Application by National Highways for A47 Wansford to Sutton Dualling

The Examining Authority's written questions and requests for information (ExQ1)

Issued on 18 January 2021

Annex B – Site Compound and Storage Areas

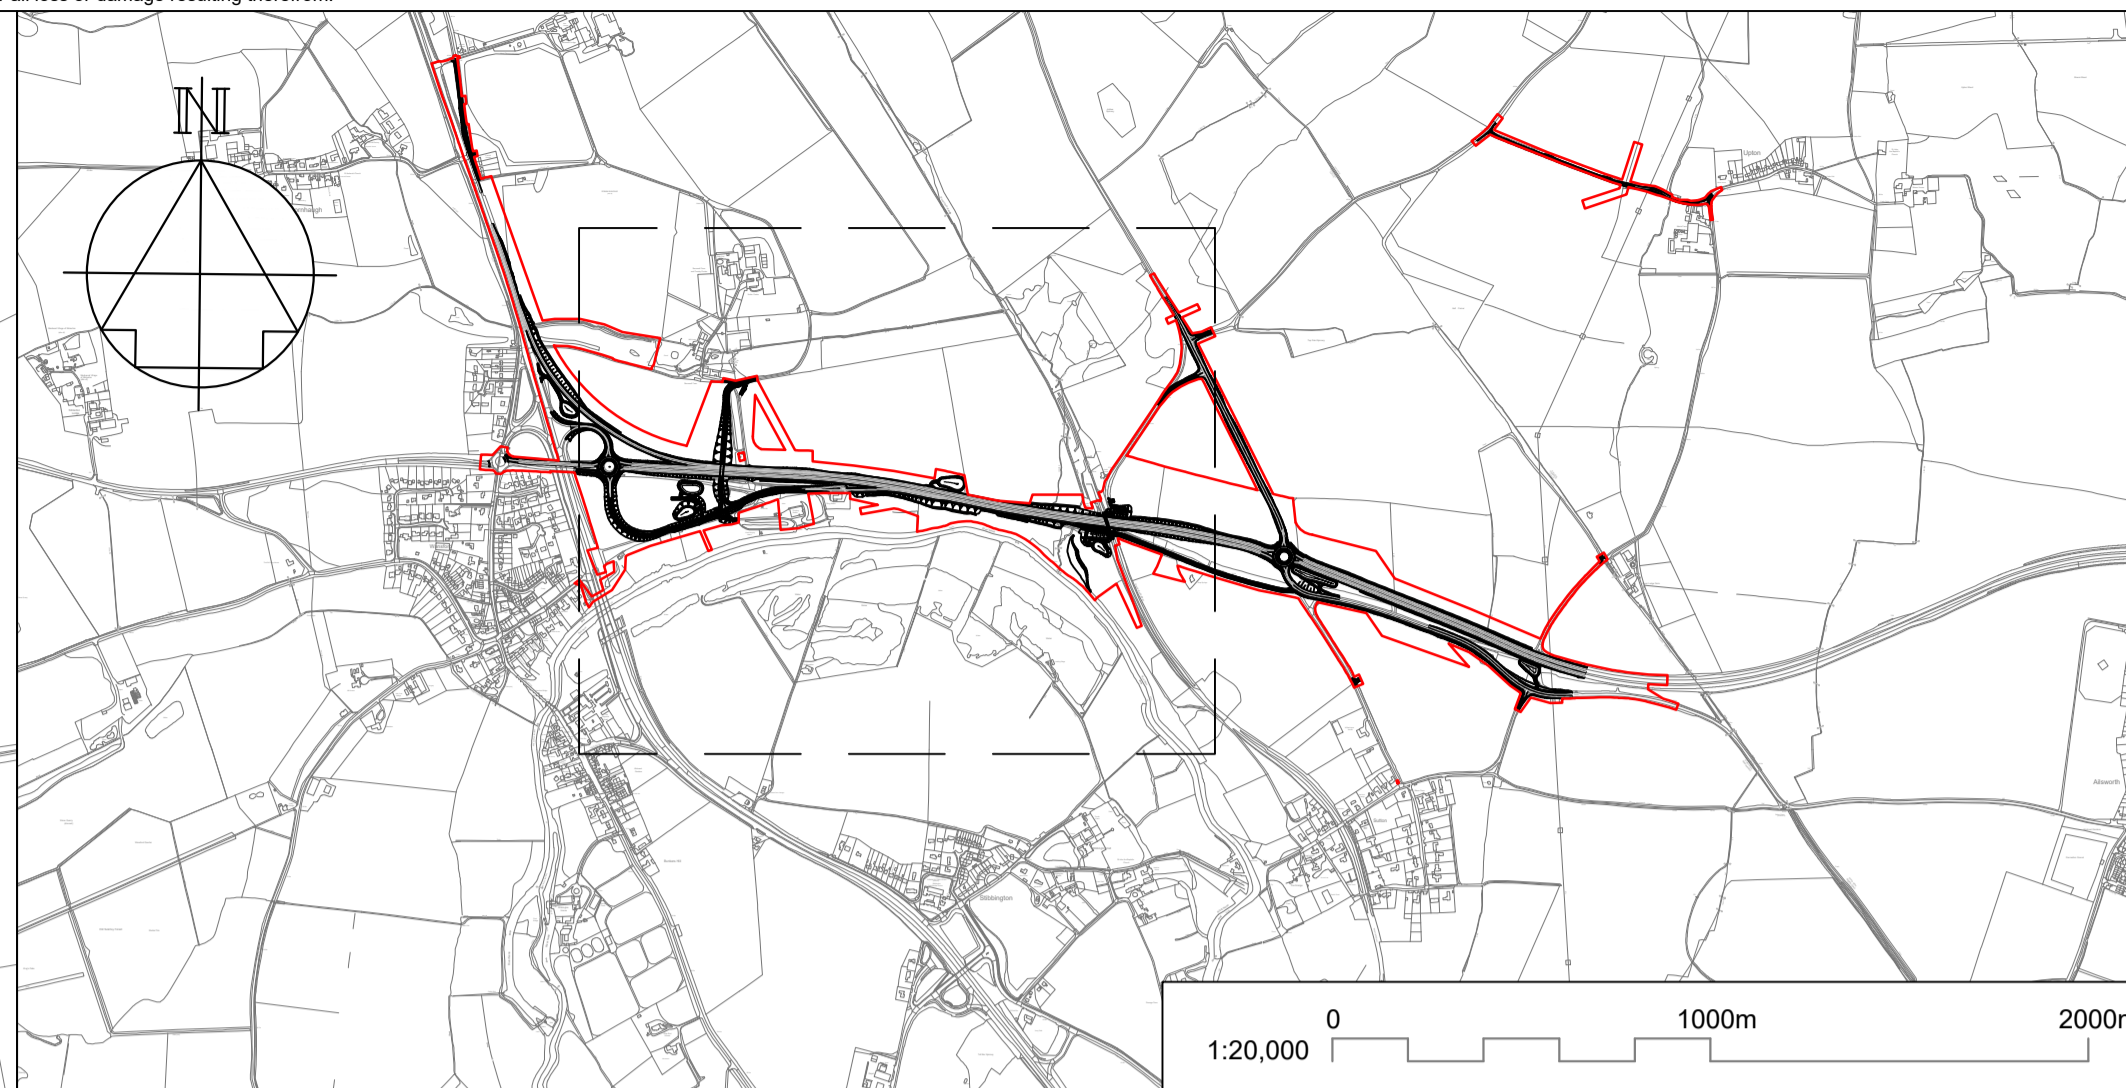
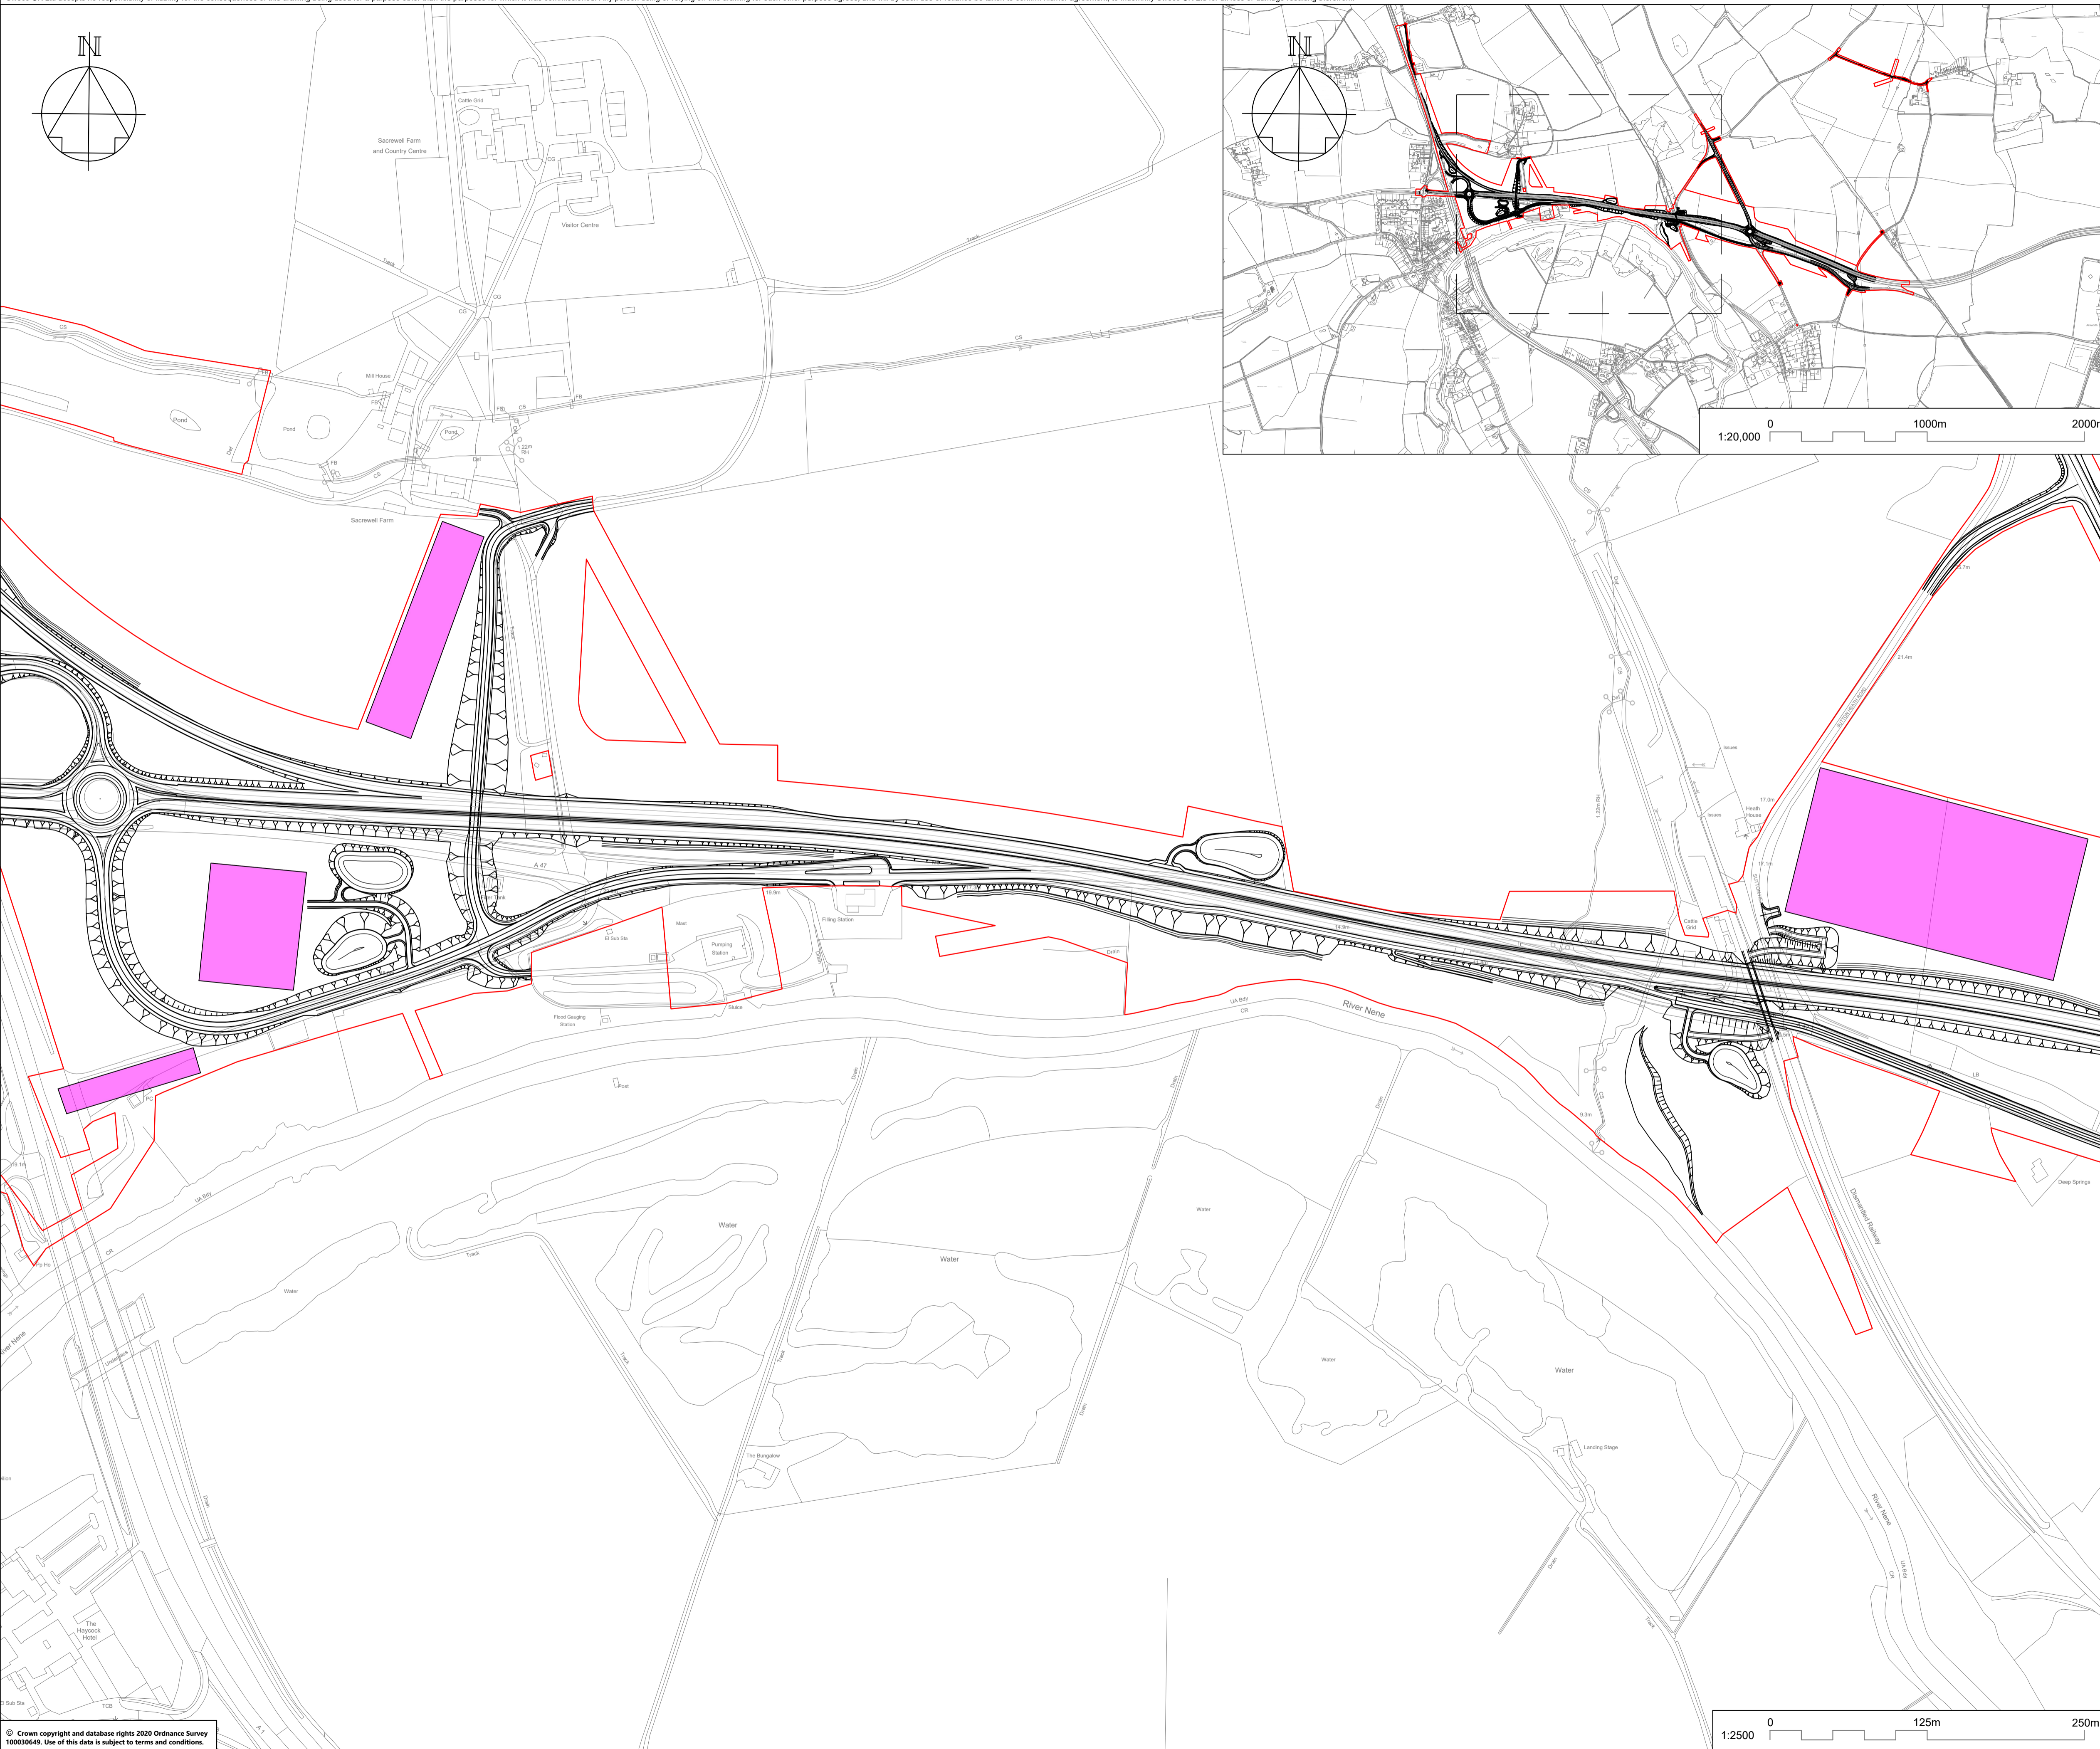
1.0.5.	The Applicant	<p>Works Plans</p> <p>The key to the original version of the Works Plans [APP-006] included "Construction Compound"; this was not included within the plans themselves and this has been omitted from the key from the revised version [AS-006]. Could the Applicant please clarify the position geographically of any proposed construction compounds.</p>
